From: Alfred Yeatman [REDACTED]
Sent: 25 August 2017 10:26
To: Simon Davis
Cc: Rachel Davies
Subject: RE: P/49/17/DOC Church Farm Holiday Village [NLP-DMS.FID263510]

Following further work to the Church Farm drainage scheme we attach updated drawings and associated calculations.

CLIENT		
BOURNE LEISURE		
PROJECT		
CHURCH FARM GOLF DEVELOPMENT, CHURCH FARM HOLIDAY PARK, PAGHAM, PO21 4NR		
DRAWING TITLE		
CHURCH FARM GOLF DEVELOPMENT DRAINAGE LAYOUT FOR PLANNING 1 OF 2		
PROJECT No.	DRAWING No.	REV.
J-11399	3001	C

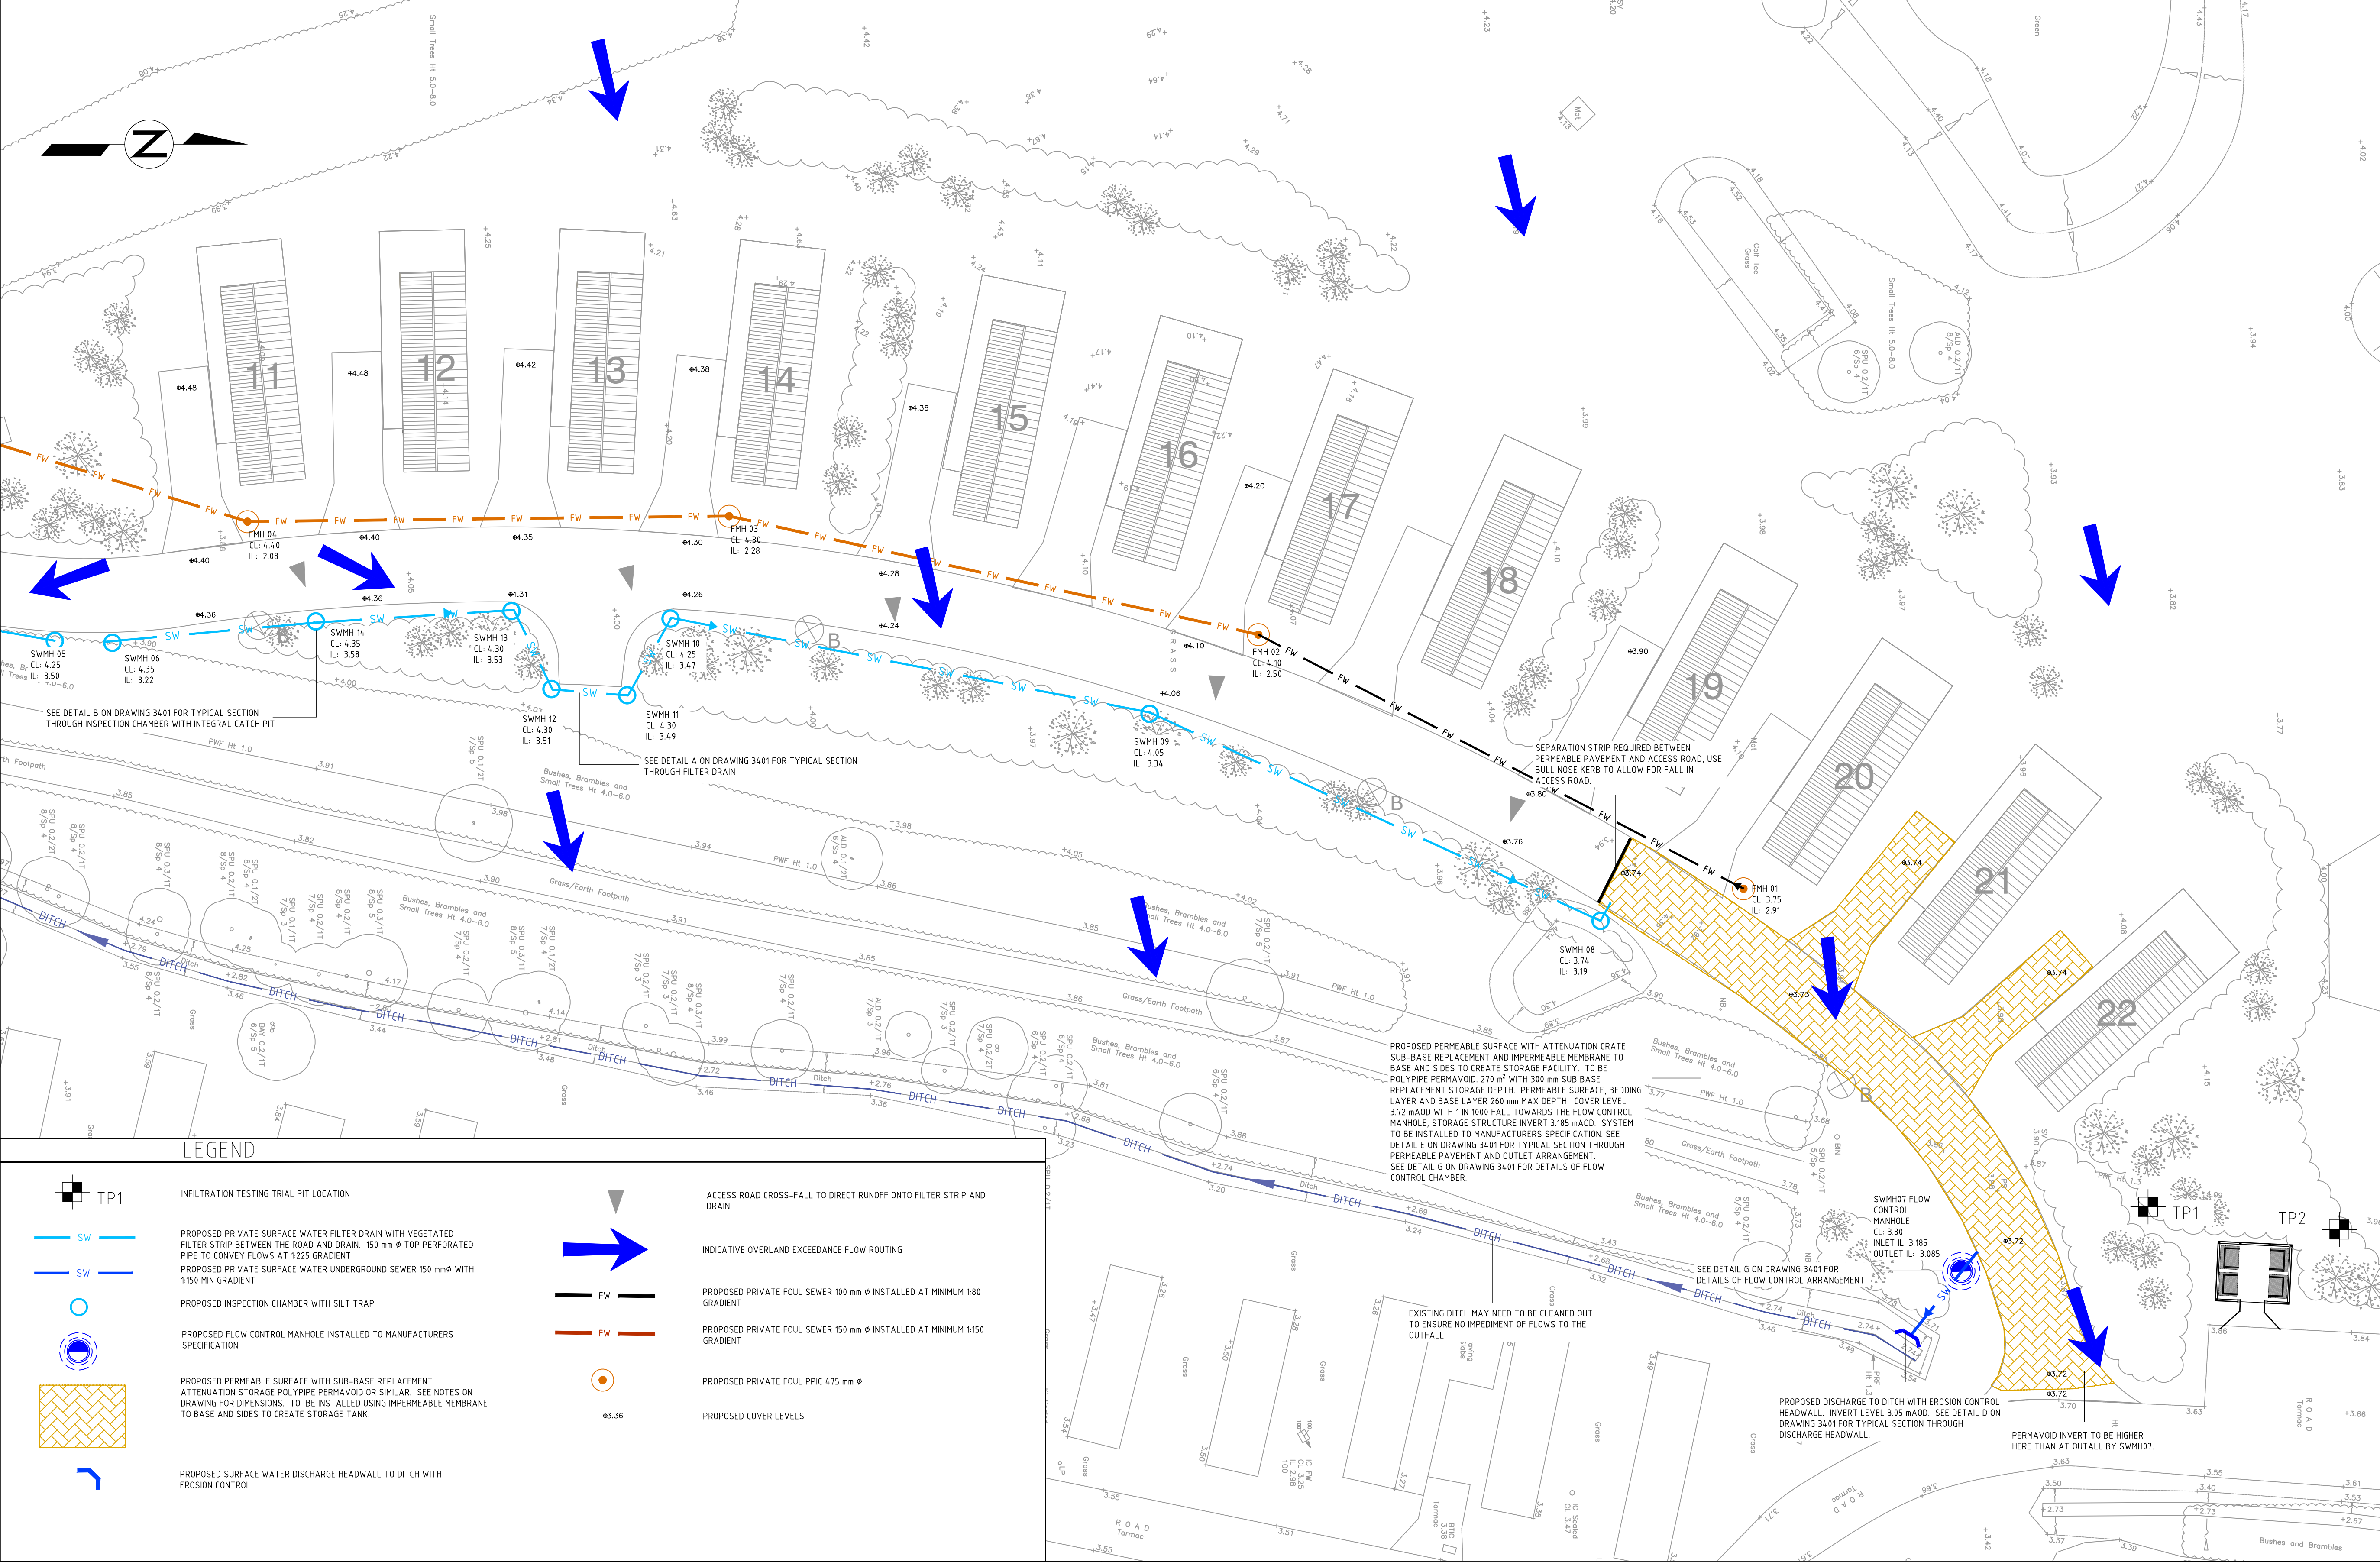
- 1. All manholes on filter drain to contain silt traps. Additional manhole access required. Ie. on heads of each system/at all significant changes of direction/at intervals not exceeding 50m. **See amendments to drawings 3001 and 3002.***

- 4. Specify levels/gradient of filter drain. **See levels on drawings 3001 and 3002.***
- 5. Show finished surface levels for access road/permeable paving. **See levels on drawings 3001 and 3002.***

- 6. Existing ditch may need to be cleaned out to ensure no impediment of flows (add note to drawing). **Note added see drawings 3001 and 3002.***
- 7. Provide calculations to prove that excess water can be stored above ground (within the raised kerb area) during the 1 in 100 year storm event +30% allowance for climate change. **System has now been altered to allow for underground storage of flows in 300mm deep Permavoid structure, see MicroDrainage calculations for details. Note North catchment details have also been amended.***
